From: Martyn White
Sent: 07 December 2018 15:24
To: Planning.Responses
Cc: Zac Denton
Subject: LU/308/18/L

LU/308/18/L

The application consists of a number of proposals to a grade II Listed Building in the Rover Road Conservation Area.

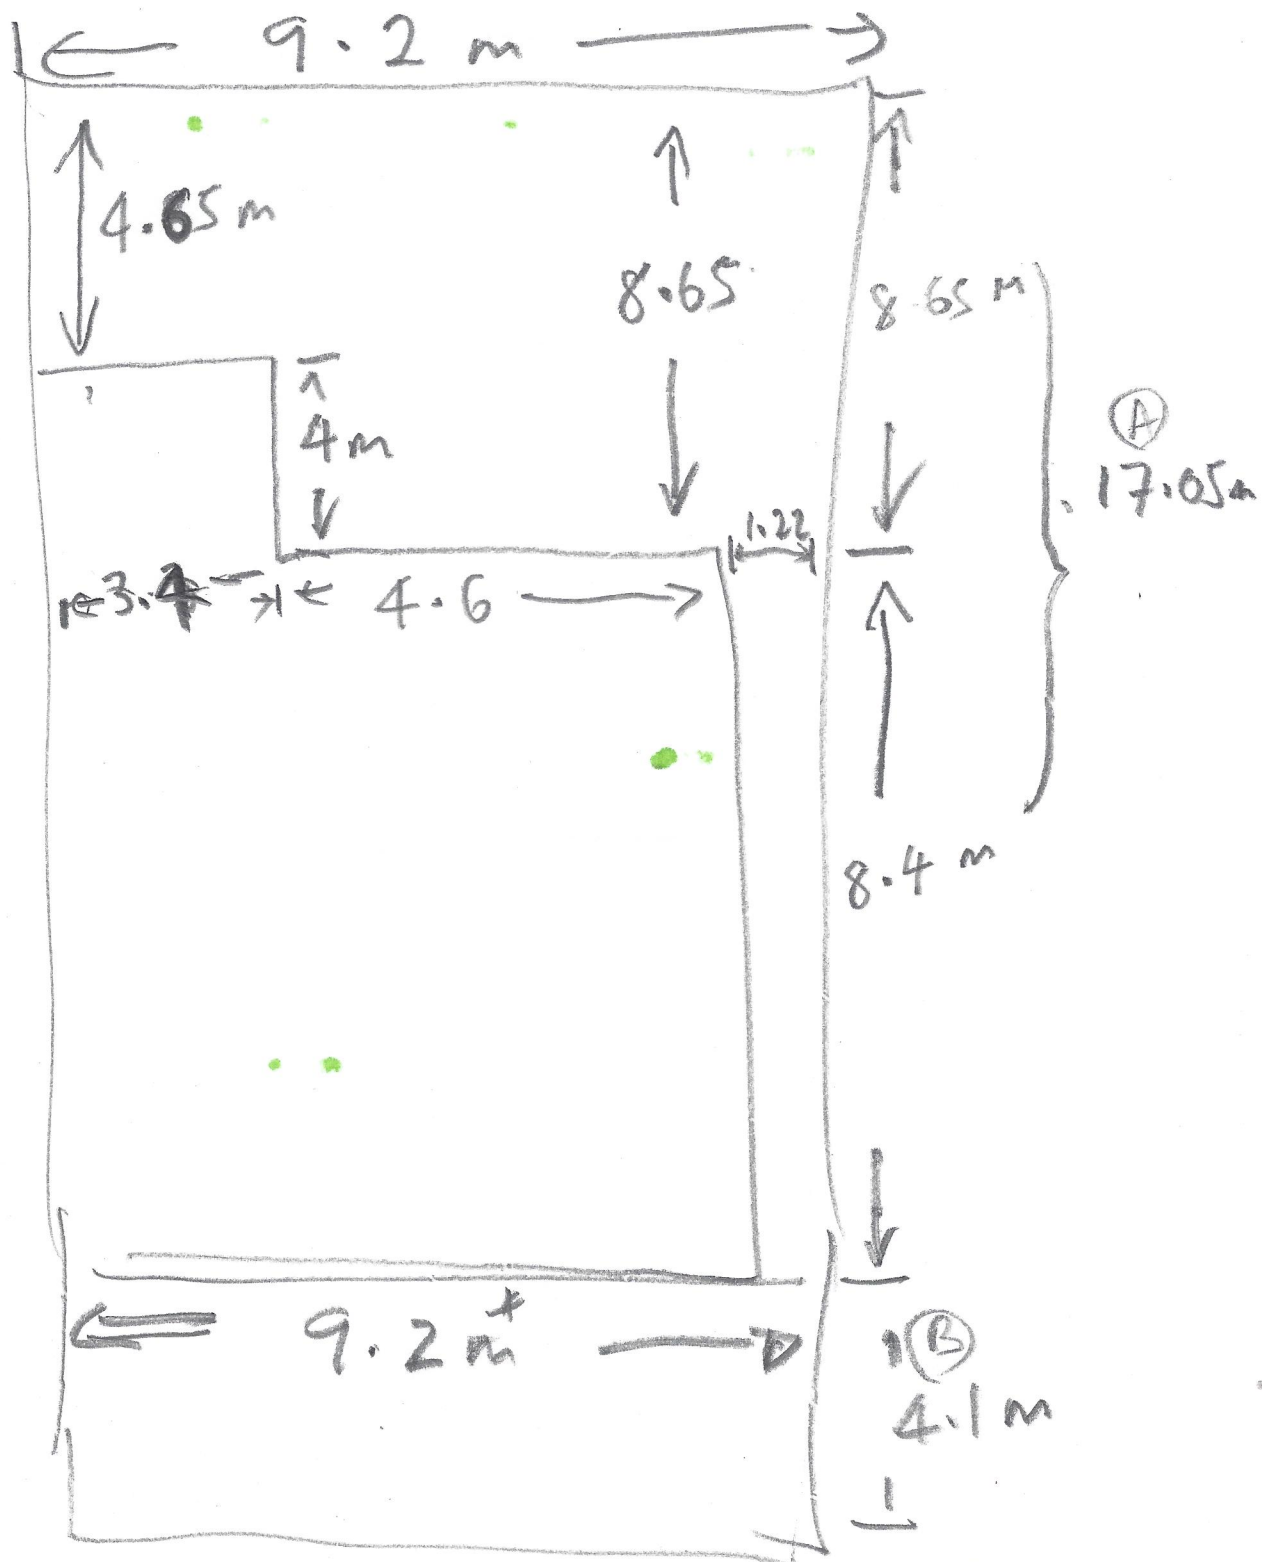
The location of the shed is not entirely clear. However, based on the pictures provided, it is assumed to be in the rear corner of the rear garden. The concept of a shed on the whole is acceptable, subject to the design/treatment. I note that the applicant wishes to paint the structure grey in an attempt to reduce its impact. Such a proposal can be supported as the structure is temporary and can easily be removed.

(A) DOOR TO BE REPLACED

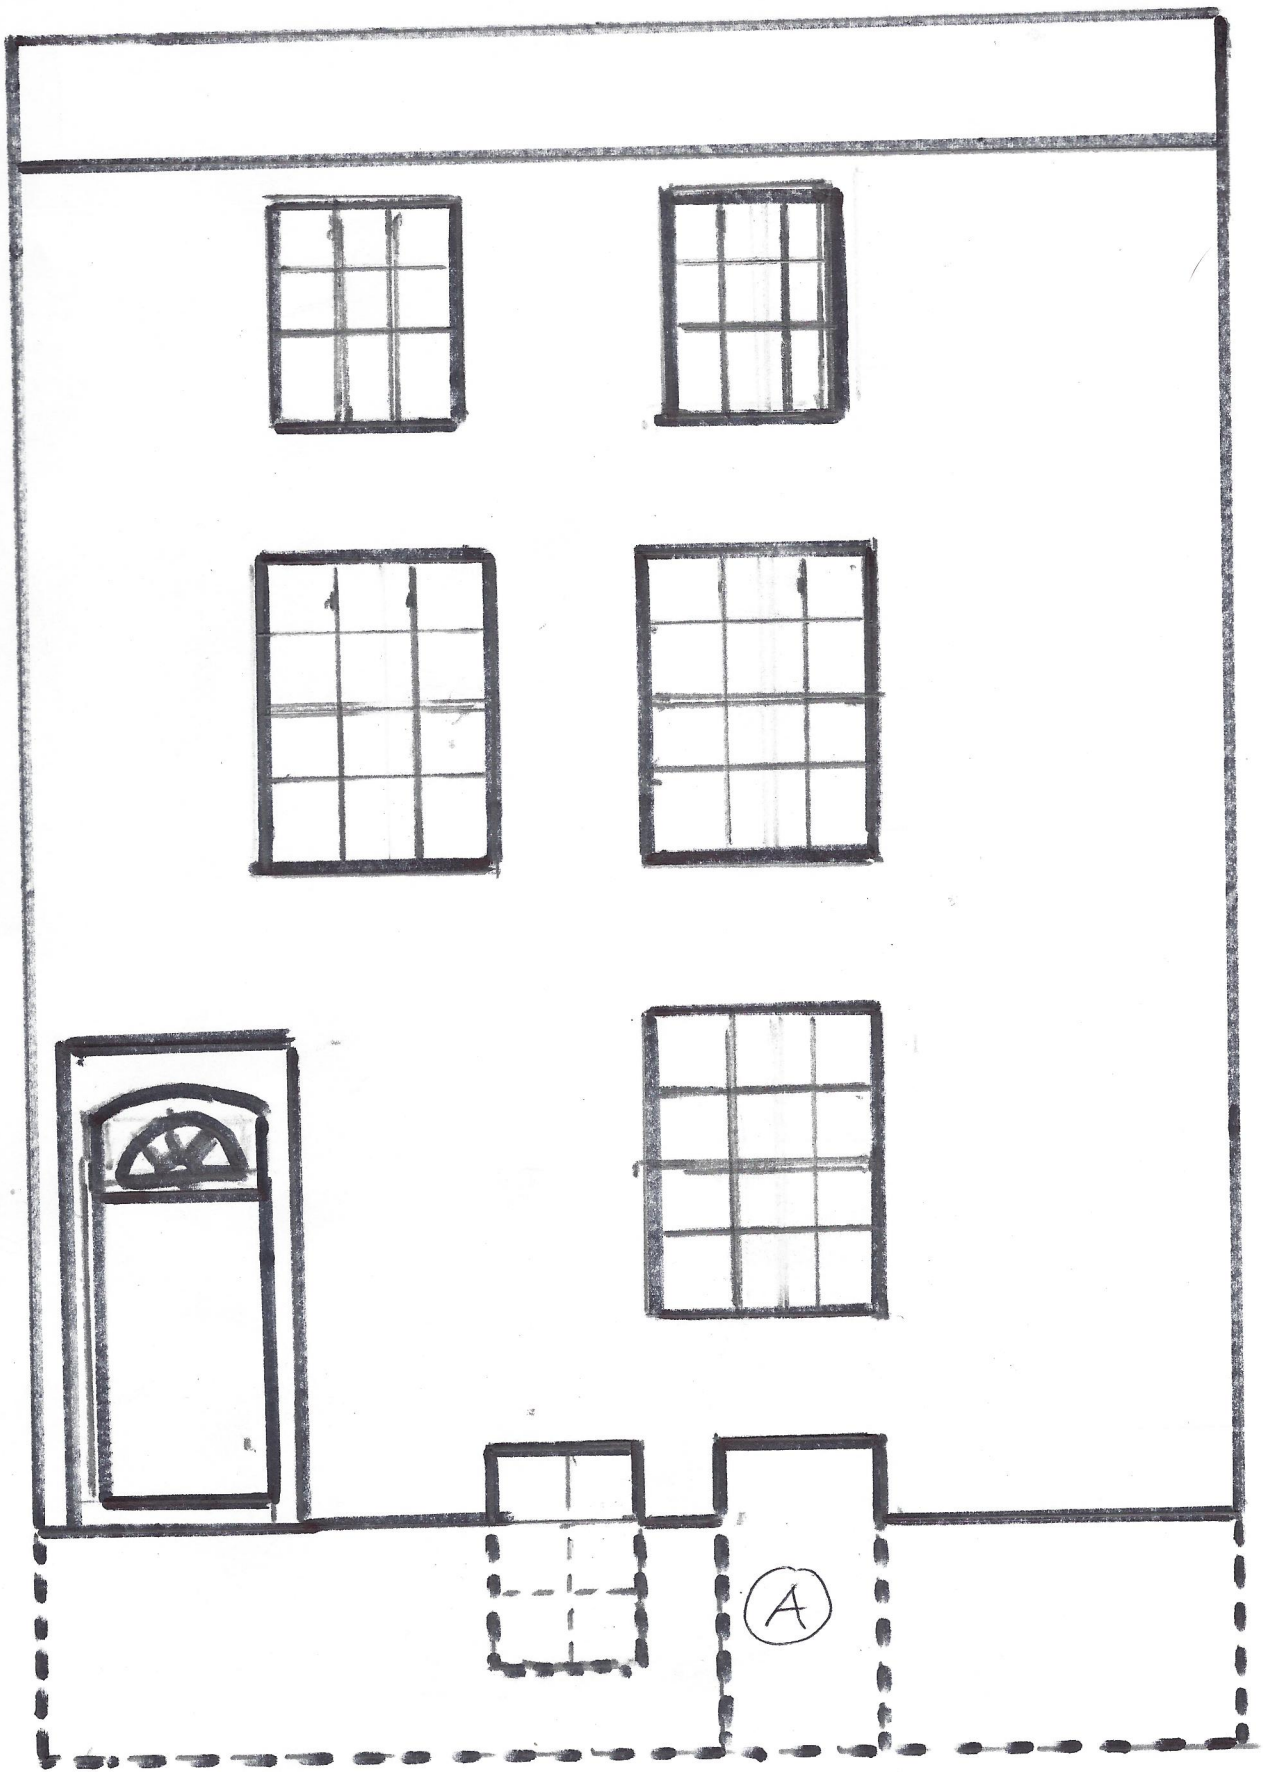
The existing basement door is of an inappropriate design for the listed building, and in a very poor state of repair. It is noted that the application is to replace the door, and a picture is provided as to its appearance. Such a proposal is considered to be acceptable, and capable of support.
